**From:** Robert Major  
**Sent:** 26 January 2017 09:44  
**To:** Sharon Craig  
**Subject:** FW: Ribble Valley ref 3-2016-0990 Ribblesdale View Chatburn 18 dwellings

**From:** TownPlanning LNW [<mailto:TownPlanningLNW@networkrail.co.uk>]  
**Sent:** 18 January 2017 08:25  
**To:** Robert Major  
**Subject:** Ribble Valley ref 3-2016-0990 Ribblesdale View Chatburn 18 dwellings

3/2016/0990  
Land to the North of Ribblesdale View Chatburn BB7 4BB  
Outline application for the erection of 18 dwellings (all matters reserved except for access)  
377127 / 444354  
(our ref: DJH 23+1351)

Title
Existing Site Plan Plan

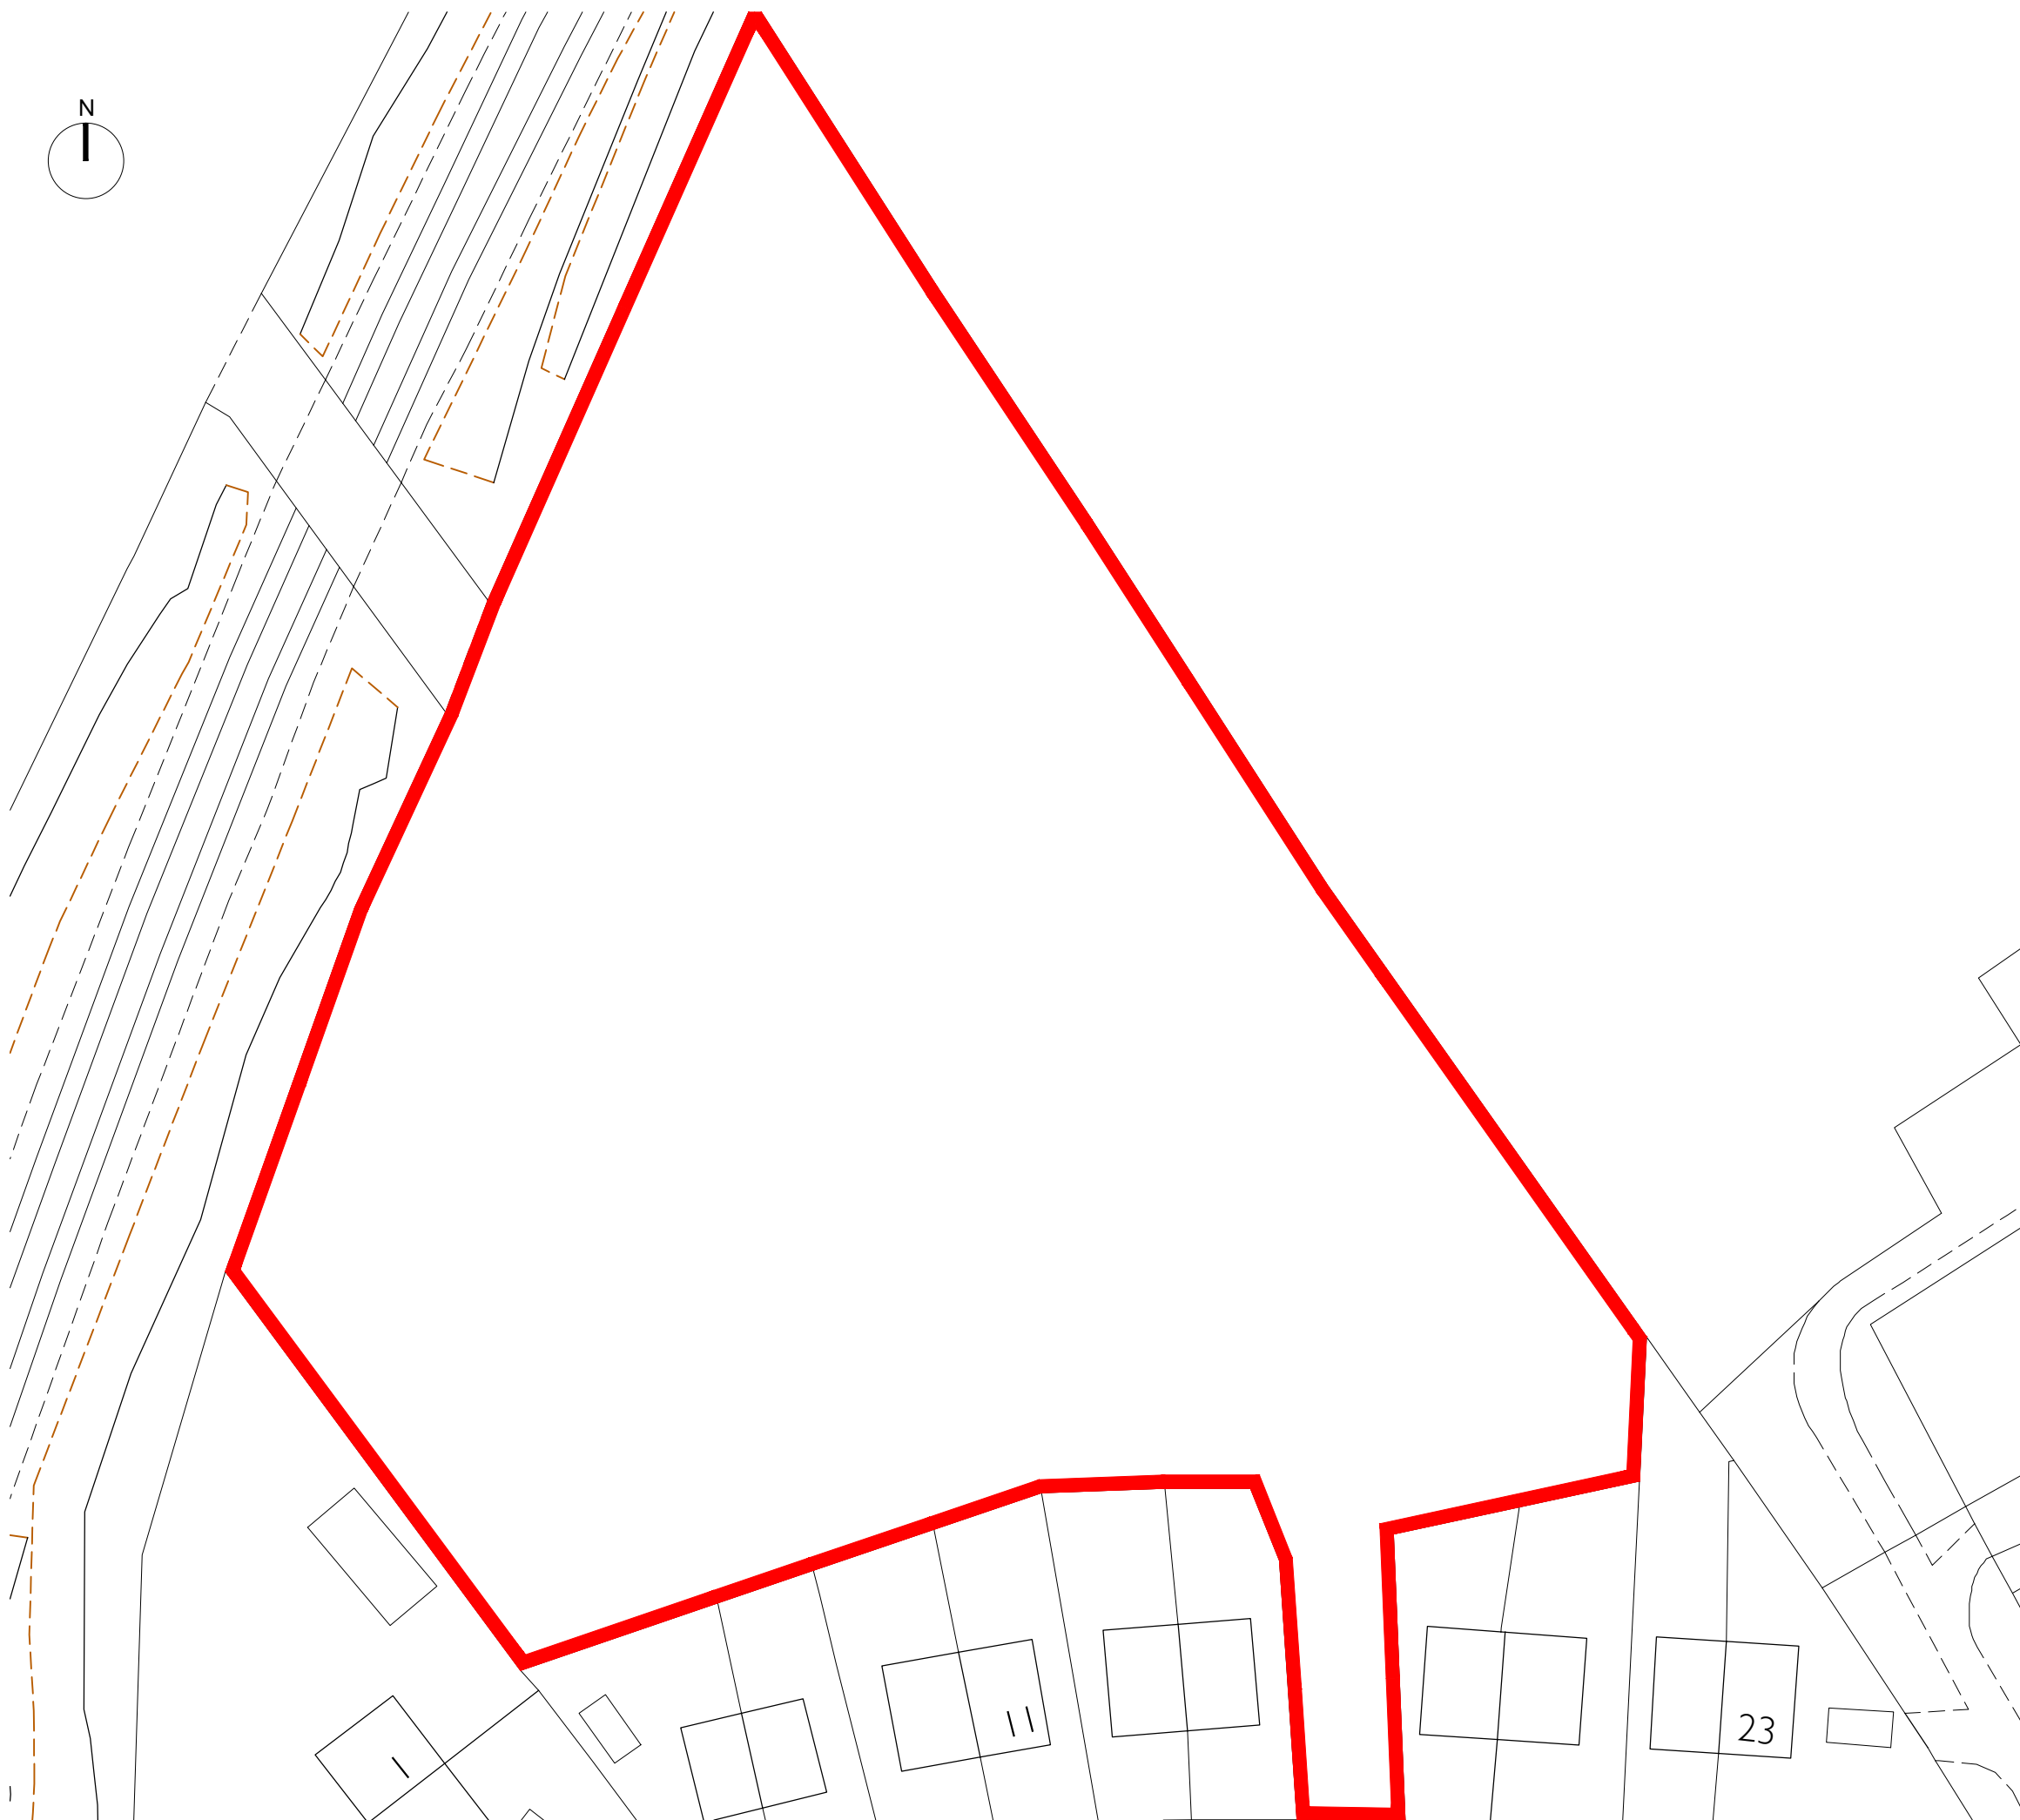
(1)  
Next to the open space is a Network Rail bridge, Hargreaves No.1. The developer may need to seek agreement with Network Rail for access from residents of the development for this bridge.
